WEST SUSSEX COUNTY COUNCIL CONSULTATION

TO:	Arun District Council FAO: Michael Eastham
FROM:	Stephen Gee Highways, WSCC
DATE:	27/11/18
LOCATION:	Land east of, Tye Lane, Walberton
SUBJECT:	WA/99/18/DOC Application for approval of details reserved by conditions imposed on planning reference WA/44/17/OUT relating to conditions 5, 9, 10, 11, 12 13, 16, 17, 24, 25, 27, 28, 30, 32, 33, 36, 41, 42 and 43.
DATE OF SITE VISIT:	
RECOMMENDATION:	☐ Advice ☒ Objection ☐ Modification ☐ No Objection ☒ More Information ☐ Refusal
S106 CONTRIBUTION TOTAL:	£ See below for breakdown.

Do not scale from this drawing. Refer to figured dimensions only.
Drawings are produced for planning purposes and are not a construction issue.

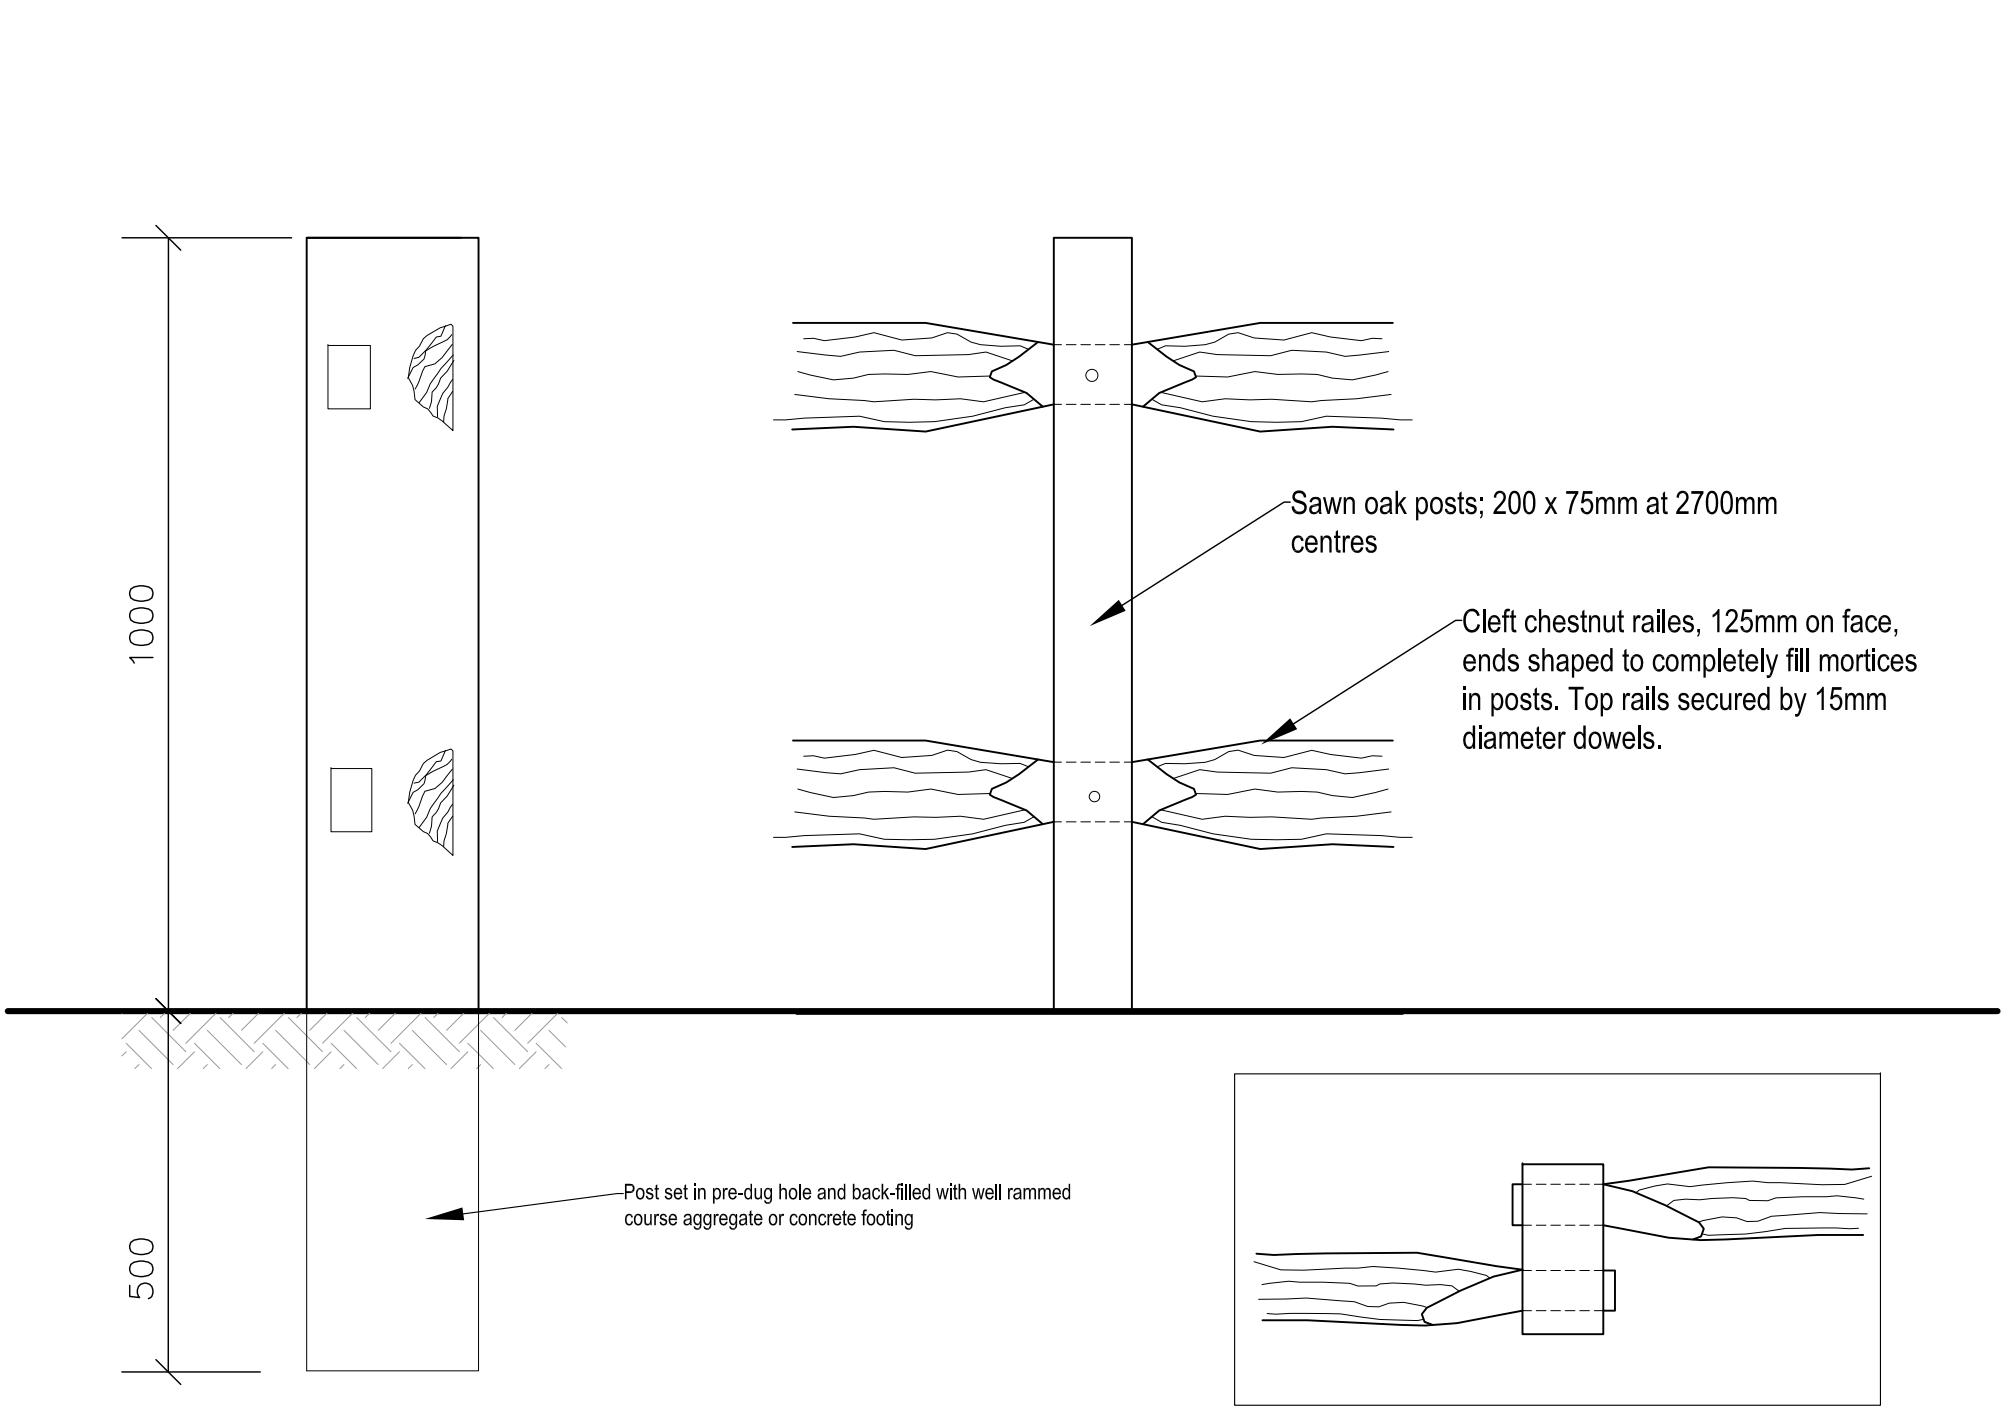
An objection is raised. The swept path plan provided appear to show an overhang at the northern drives, when comparing this to the public open space landscape proposals it appears to show the overhang area would have timber bollards of 900mm high placed within the area.

Additional close up detail of the tracking should be provided to confirm if this is not the case, or if so the landscaping proposals amended to allow a refuse vehicle to overhang.
